From: [REDACTED]
Sent: 24 June 2019 17:13
To: Planning.Responses
Subject: FW: Repton Garage Site application Y/22/19/PL
Attachments: 1801 02 B site plan proposed.pdf; 1801 03 B plans proposed.pdf; 1801 04 B elevations proposed.pdf; 1801 05 A sections proposed.pdf; 1801 06 A street elevations.pdf; 1801 07 B block plans.pdf; 1801 08 A existing plan and elevations.pdf

From: Peter Mountford [REDACTED]
Sent: 21 June 2019 14:31
To: Maria Tomalova
Cc: Natalie McKellar; Kerry Simmons
Subject: Repton Garage Site application Y/22/19/PL

PROJECT		CLIENT	DATE	DRAWN
Reptune Garage site Main Road YAPTUN		P Mountford	Feb 2019	pm
DRAWING	SCALE	REV		
Proposed plans	1:100@A3	1801/03

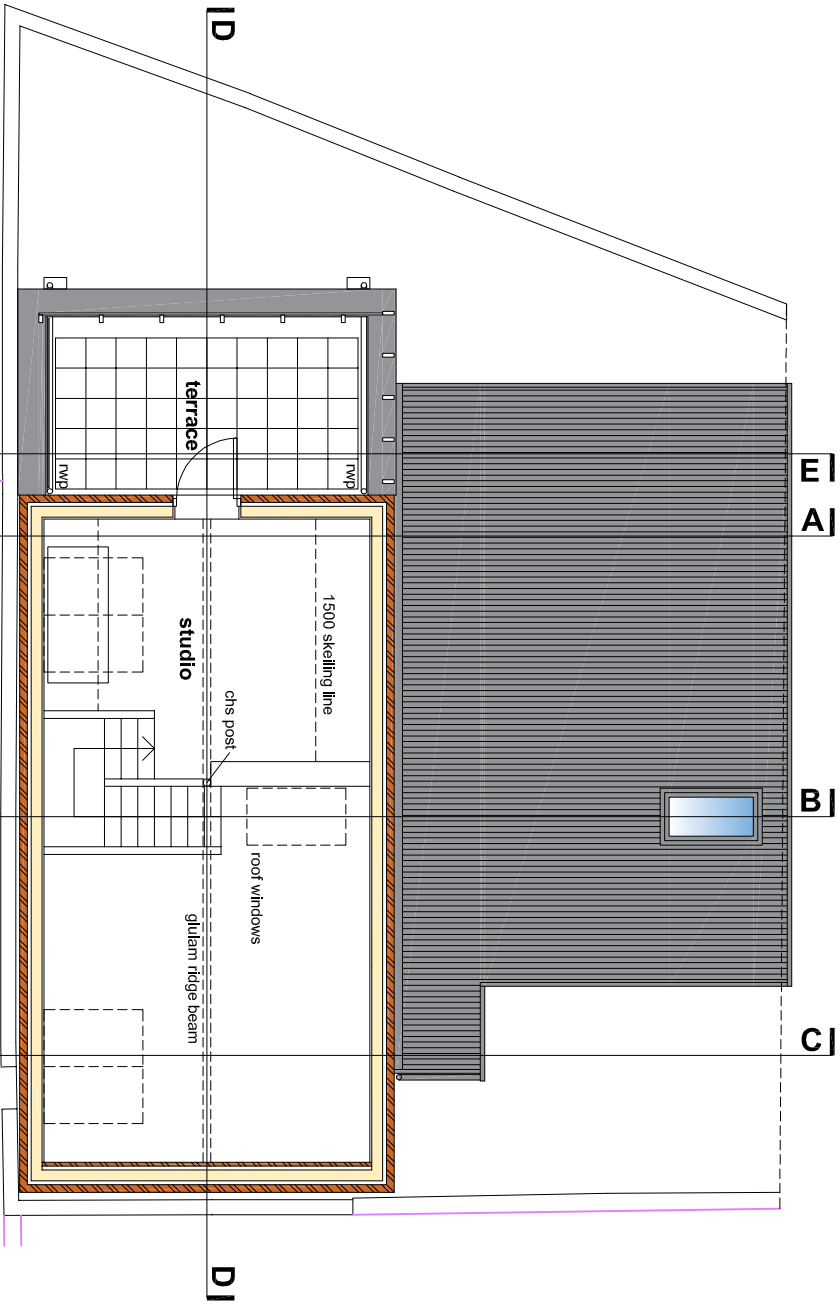
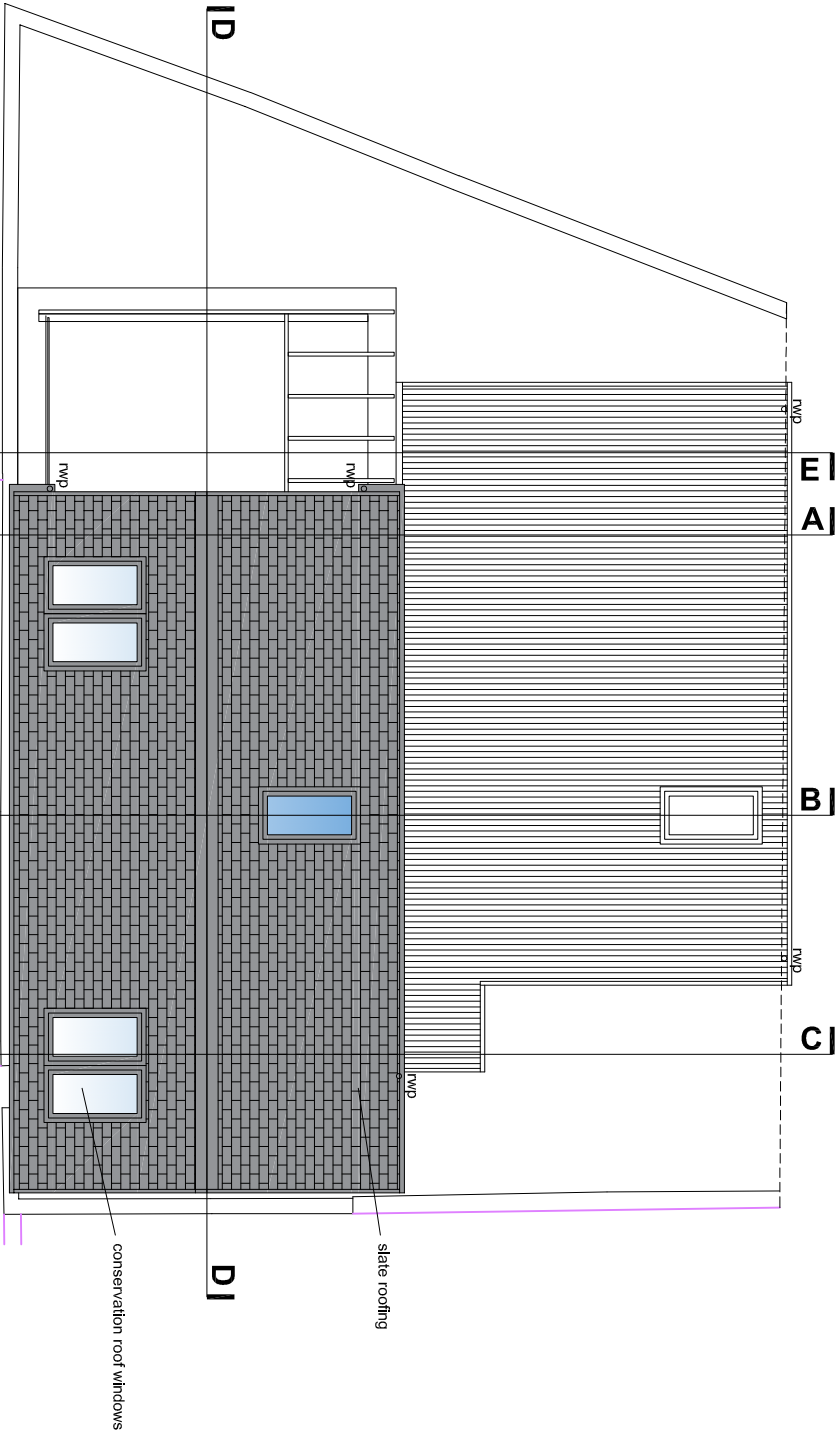
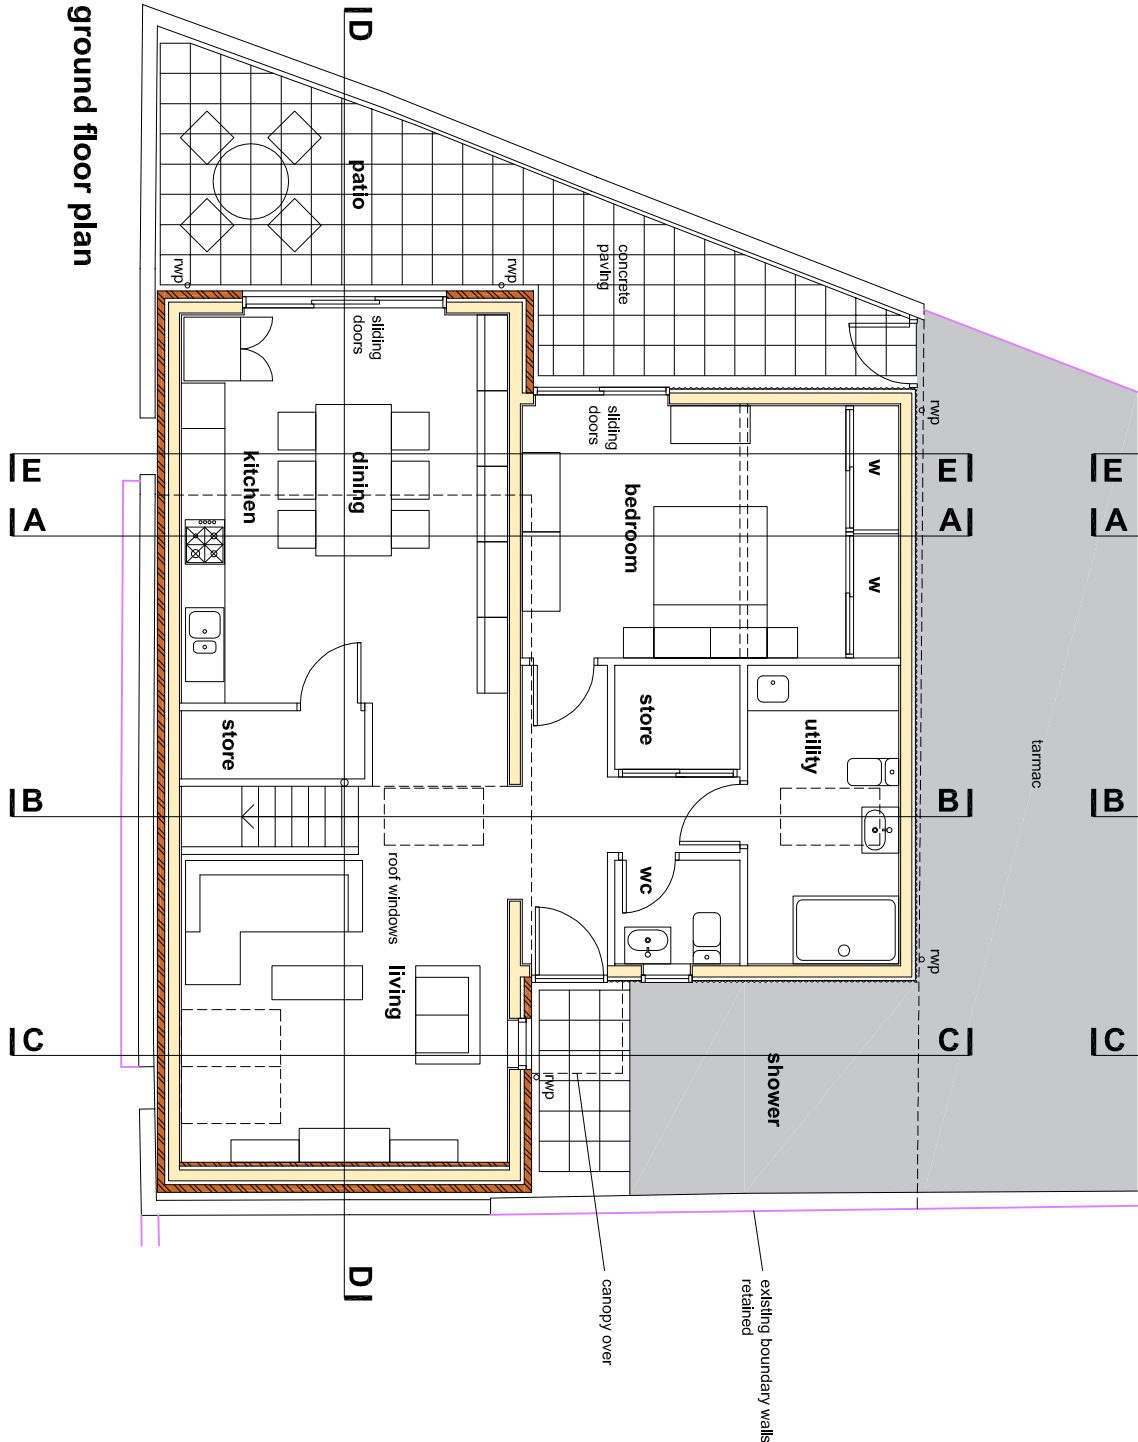
1. The proposed roof terrace has been removed and replaced with an extension to the lower roof. To provide some outdoor amenity space with a view to the fields to the south, it is now proposed to lower the height of the garden wall.

2. Your suggestion of a large living room window is welcomed, and this has been added.
3. To replace the loss of light from the glazed roof terrace door to the studio, roof windows have been added to the north-facing roof. These will be fixed obscured glass to prevent overlooking to the rear of The Old Malt House.

6. Finally: to simplify the lower roof, the entrance door has been recessed to omit the proposed canopy

PROJECT	CLIENT	DATE	DRAWN
Reptune Garage site Main Road YAPTUN	P Mountford	Feb 2019	pm
DRAWING	SCALE	DRAWING NO	REV
Proposed sections	1:100@A3	1801/05	A

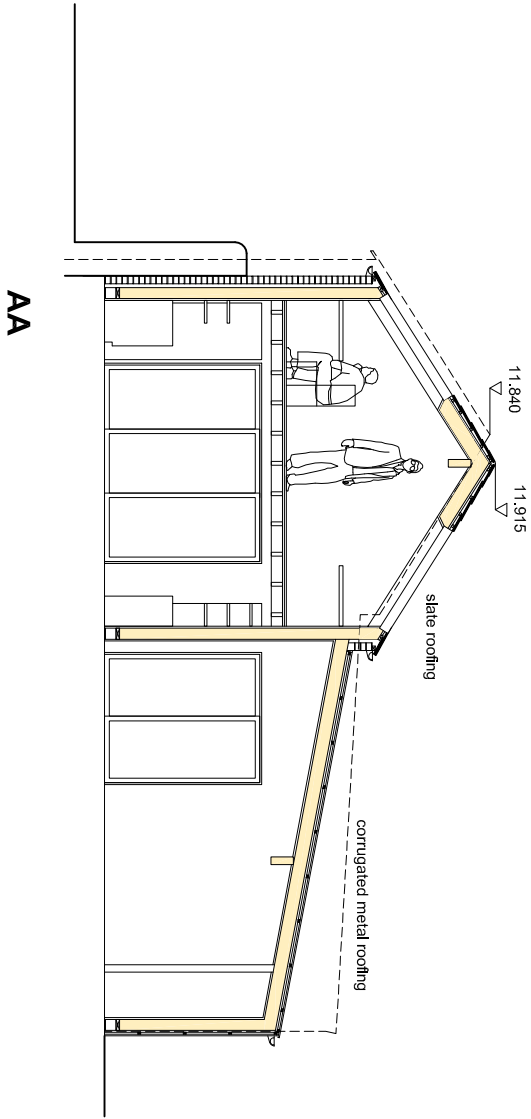
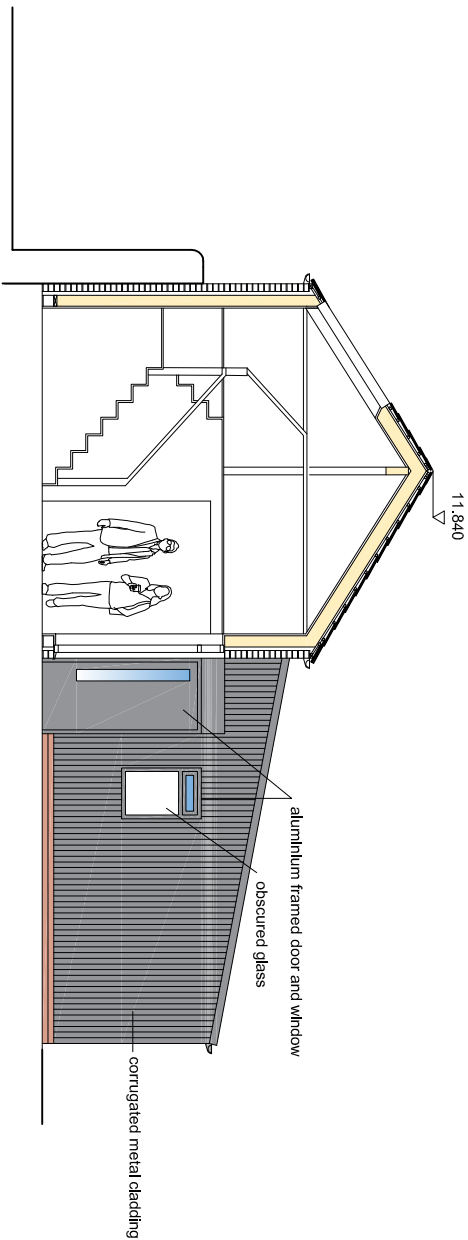
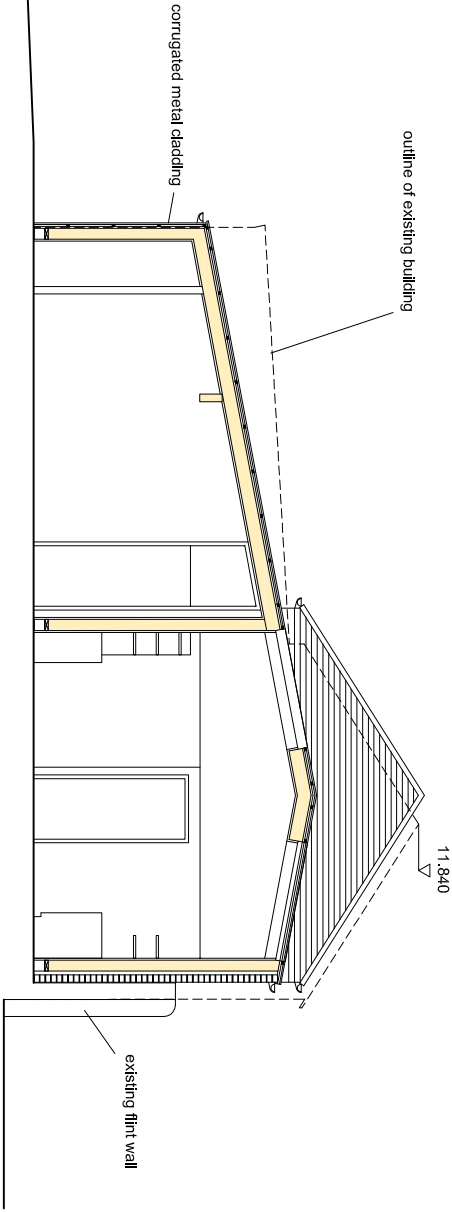
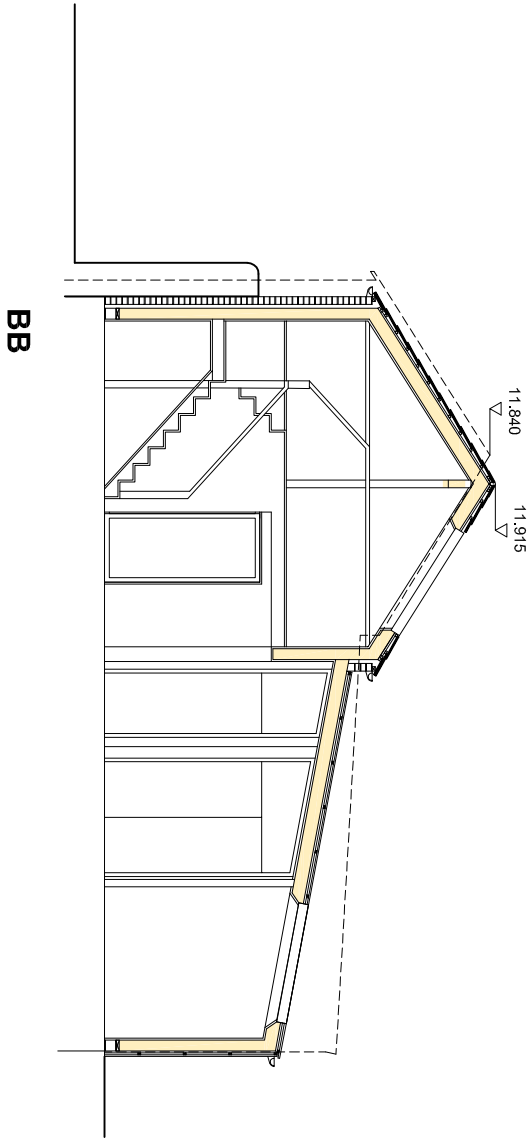
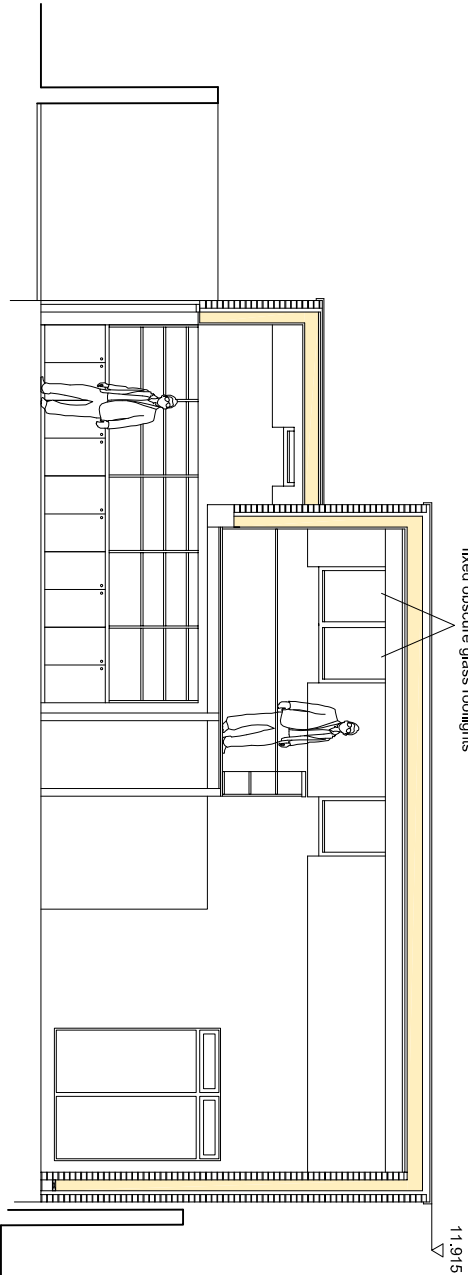
4. We discussed the proposed ridge height of the main roof relative to existing, and you indicated that some flexibility might be acceptable here, so this has been adjusted to 75mm above the surveyed ridge height on the existing roof. Headroom within the building is constrained, so any leeway is greatly appreciated.
